4th August 2021

Re: Planning application WA/63/21/PL: Land East of Tye Lane, Walberton.

VIEWPORT 1 - PROPOSED RESIDENTIAL ACCESS AT TYE LANE

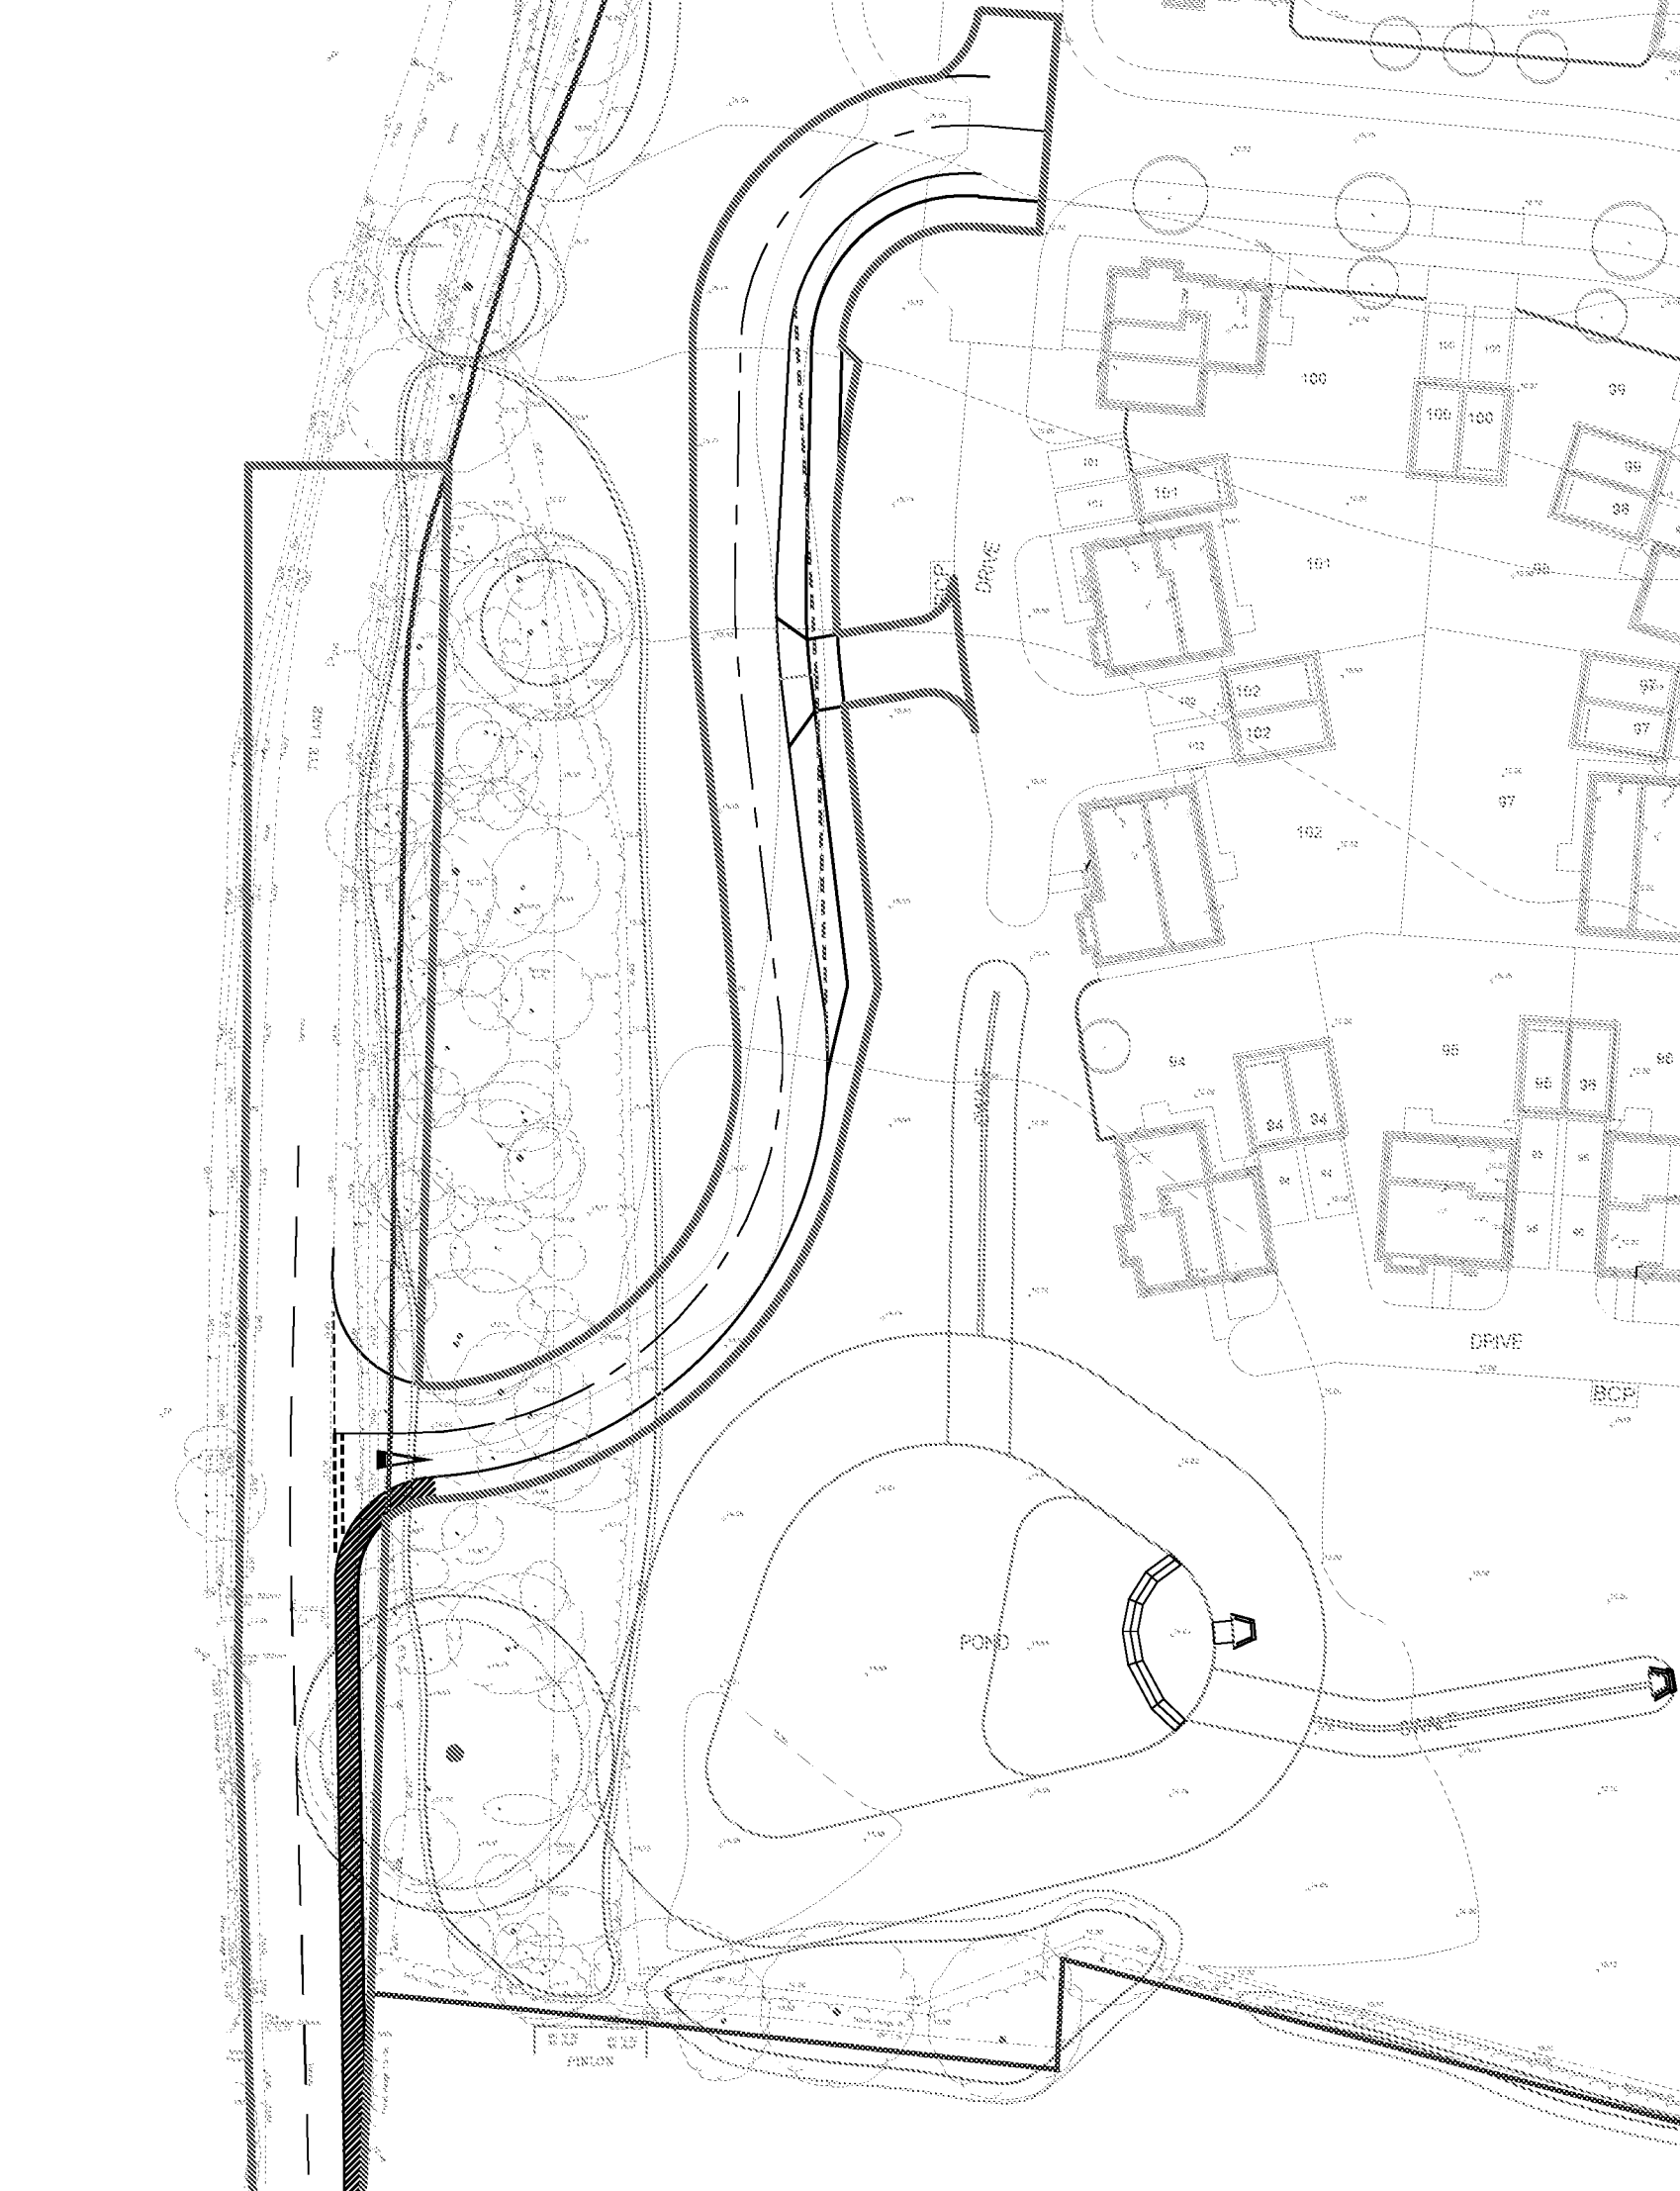
B. Road width change -Tye Lane is significantly narrower than Yapton Lane for vehicle movements. The new application reduces Tye Lane to a minimum of 4.8m rather than 5.0m for approximately 25m. This would mean that an HGV and a car could no longer pass at this point (there is zero clearance for such vehicles). The values used for car widths by the applicant do not include allowance or wing mirrors so vehicles would have to mount pavements to get past each other, however a number of houses own land right up to the highway boundary and also they have no parking so vehicles are parked on the road, further narrowing the lane. The proposed cycle route from Avisford Grange leads down this narrowed route. This will also pose increased risks to cyclists from traffic trying to pass them.
